COLORADO
Department of Transportation
Region 2 Permits

September 19, 2022

RE: Flying Horse North
SKP 223 - Sketch Plan

Figure 10
TOTAL TRAFFIC - YEAR 2027
 Volumes
 AM / PM Peak Hour
 (ADT) : Average Daily Traffic

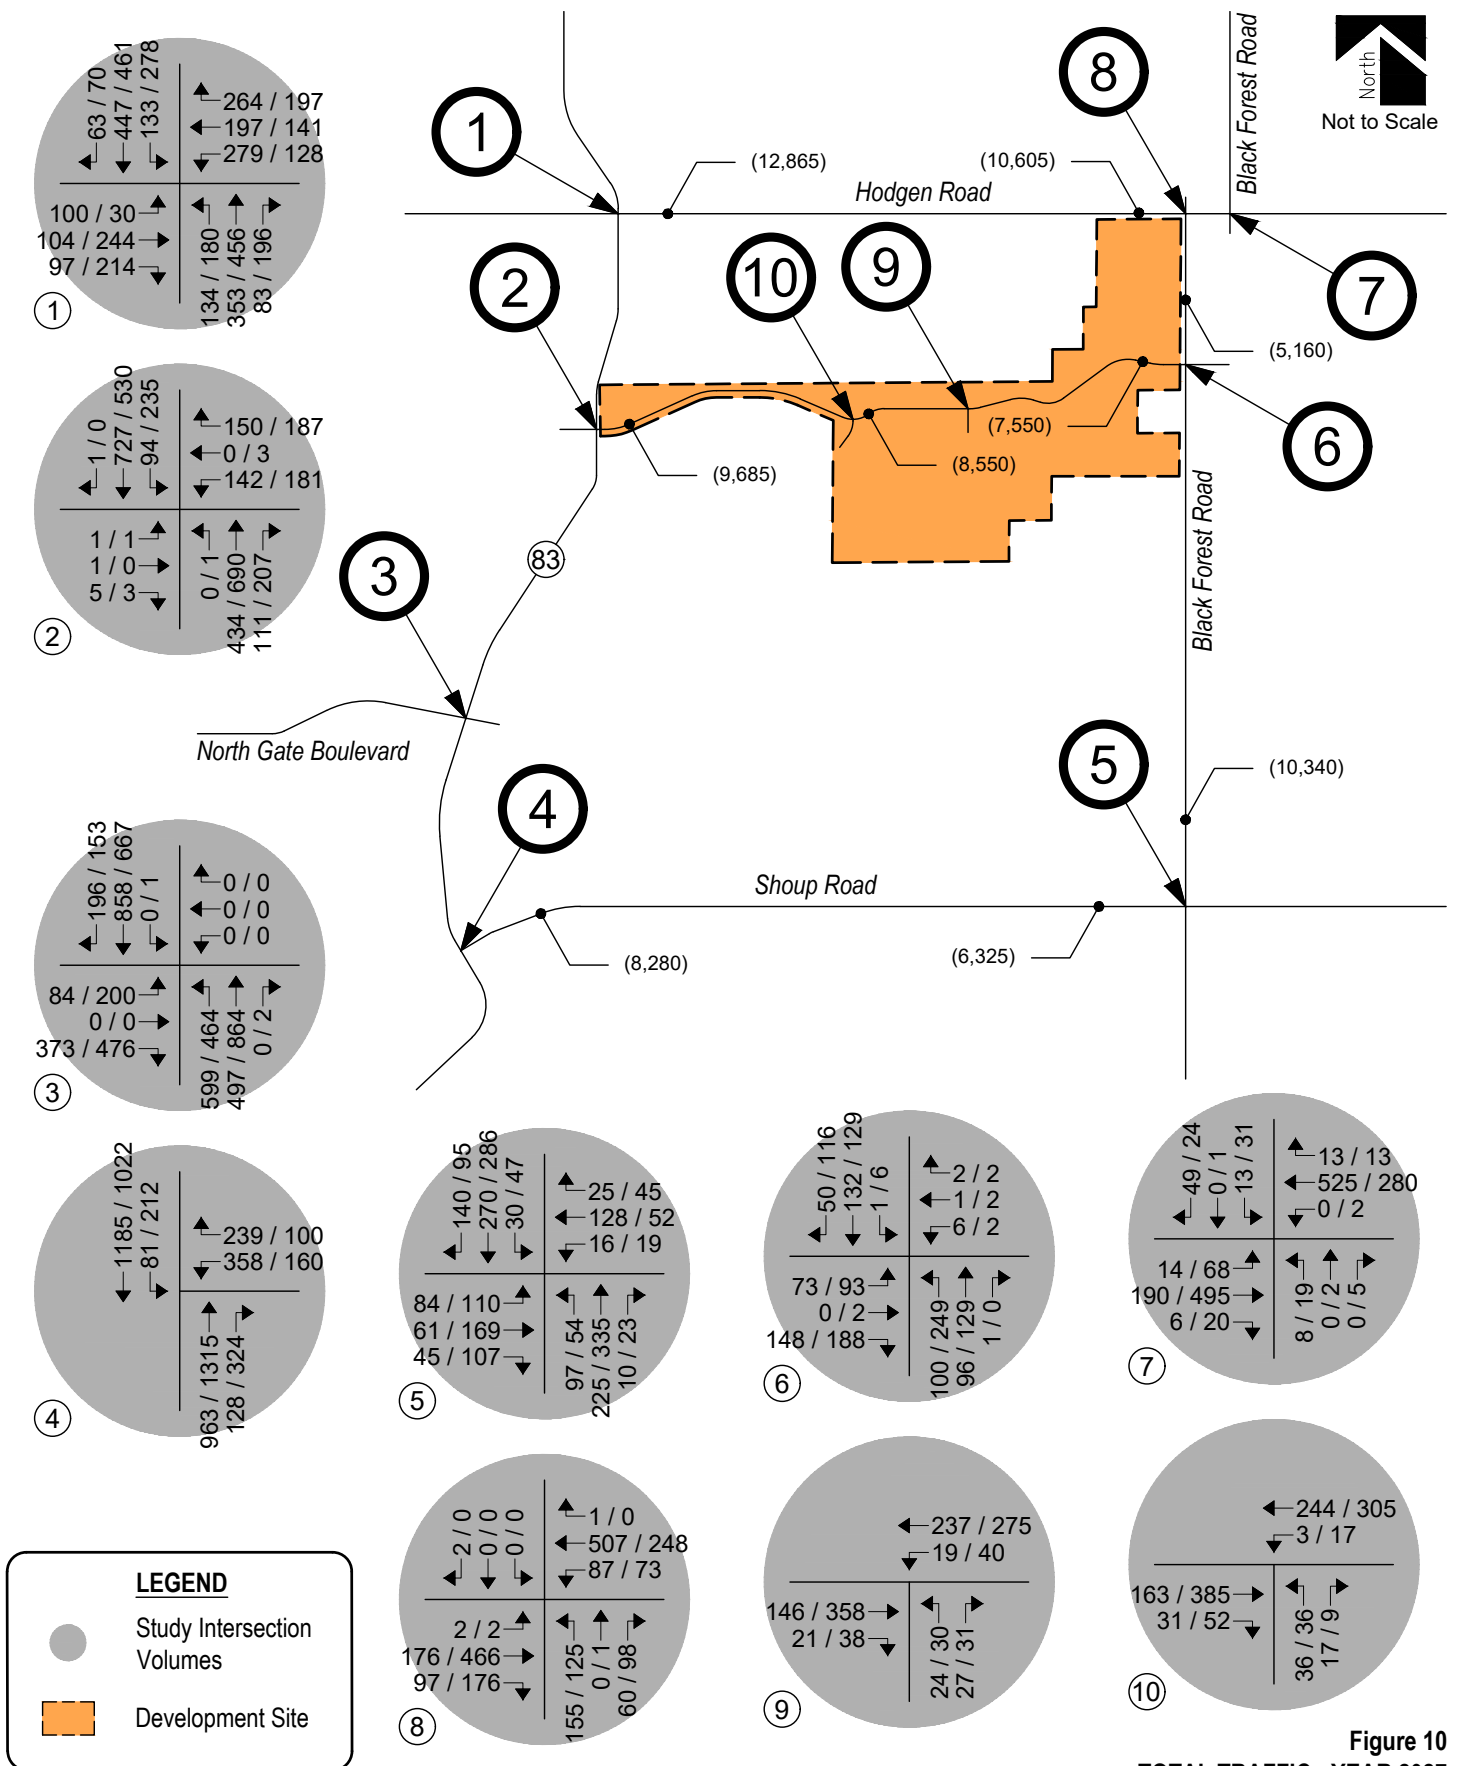
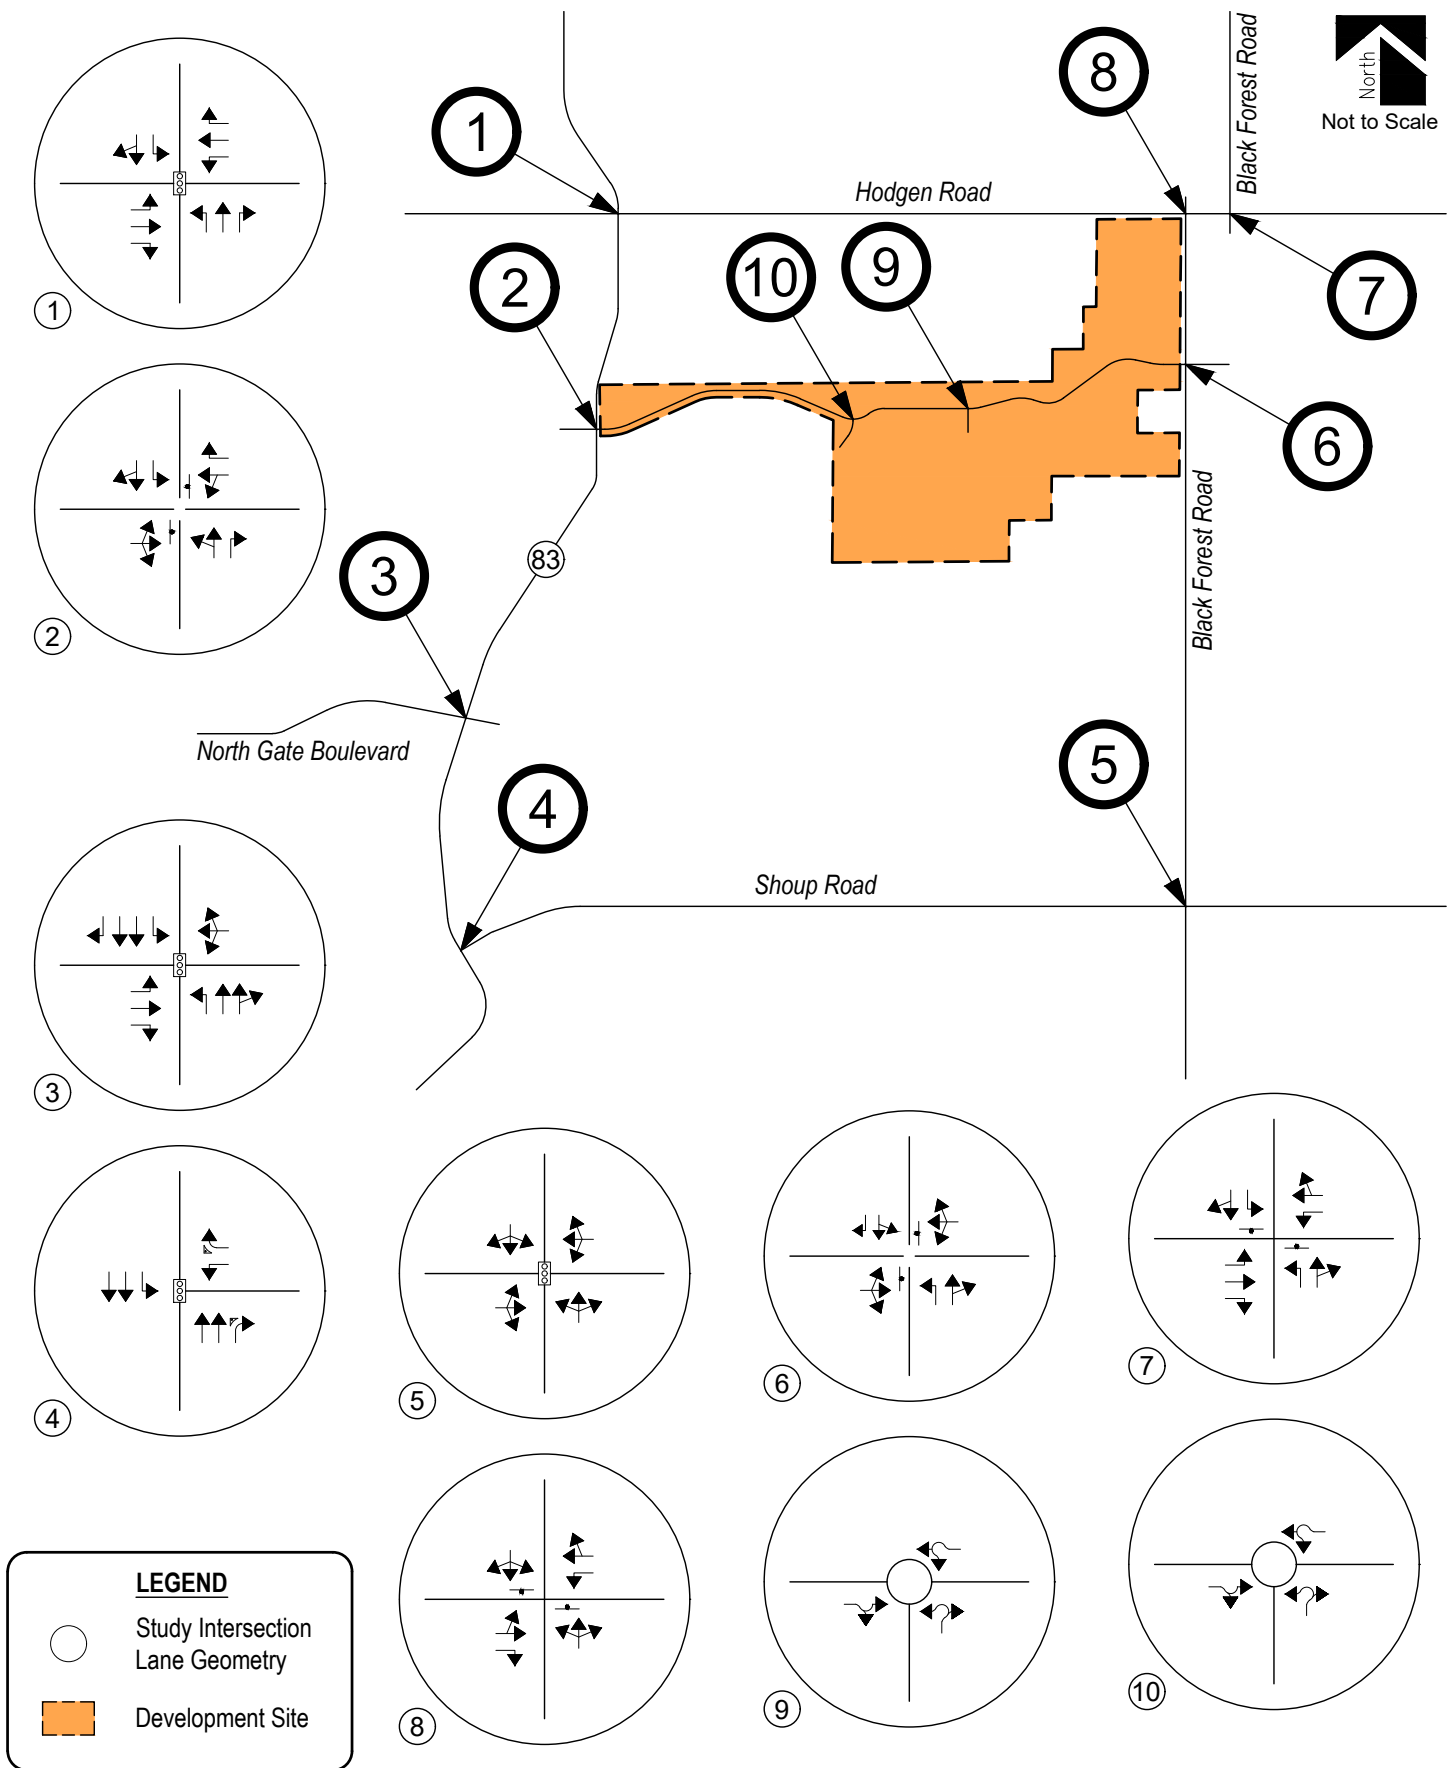
- The project generates 26,500 daily trips with approximately 70% of the trips accessing SH83 at Stagecoach. This location is planned for full movement access.

- Over the last five years the section of highway approaching Stagecoach and the intersection itself has seen an increase in traffic crashes including a fatality. The TIS indicates that signal warrants are met with the project traffic added. The PM peak would exceed capacity if signalized and require double lefts for the WB to SB direction. This in turn would require additional receiving lanes on SH83. Traffic signals are not always the most appropriate intersection control. The analysis indicates that in 2027, the roundabout functions much better with single receiving lanes and the existing approach lane configuration. Roundabouts have a much higher safety record than traffic signals resulting in about a 70% reduction in predicted crashes. Furthermore, the implementation of a roundabout at this location would help to control travel speed through this immediate area.

- As part of the access permit offer, CDOT will require the design and construction of a roundabout to facilitate site access at the intersection of SH83 & Stagecoach. The TIS should be modified to accommodate this requirement

- Therefore, CDOT requests the TIS be amended and resubmitted.
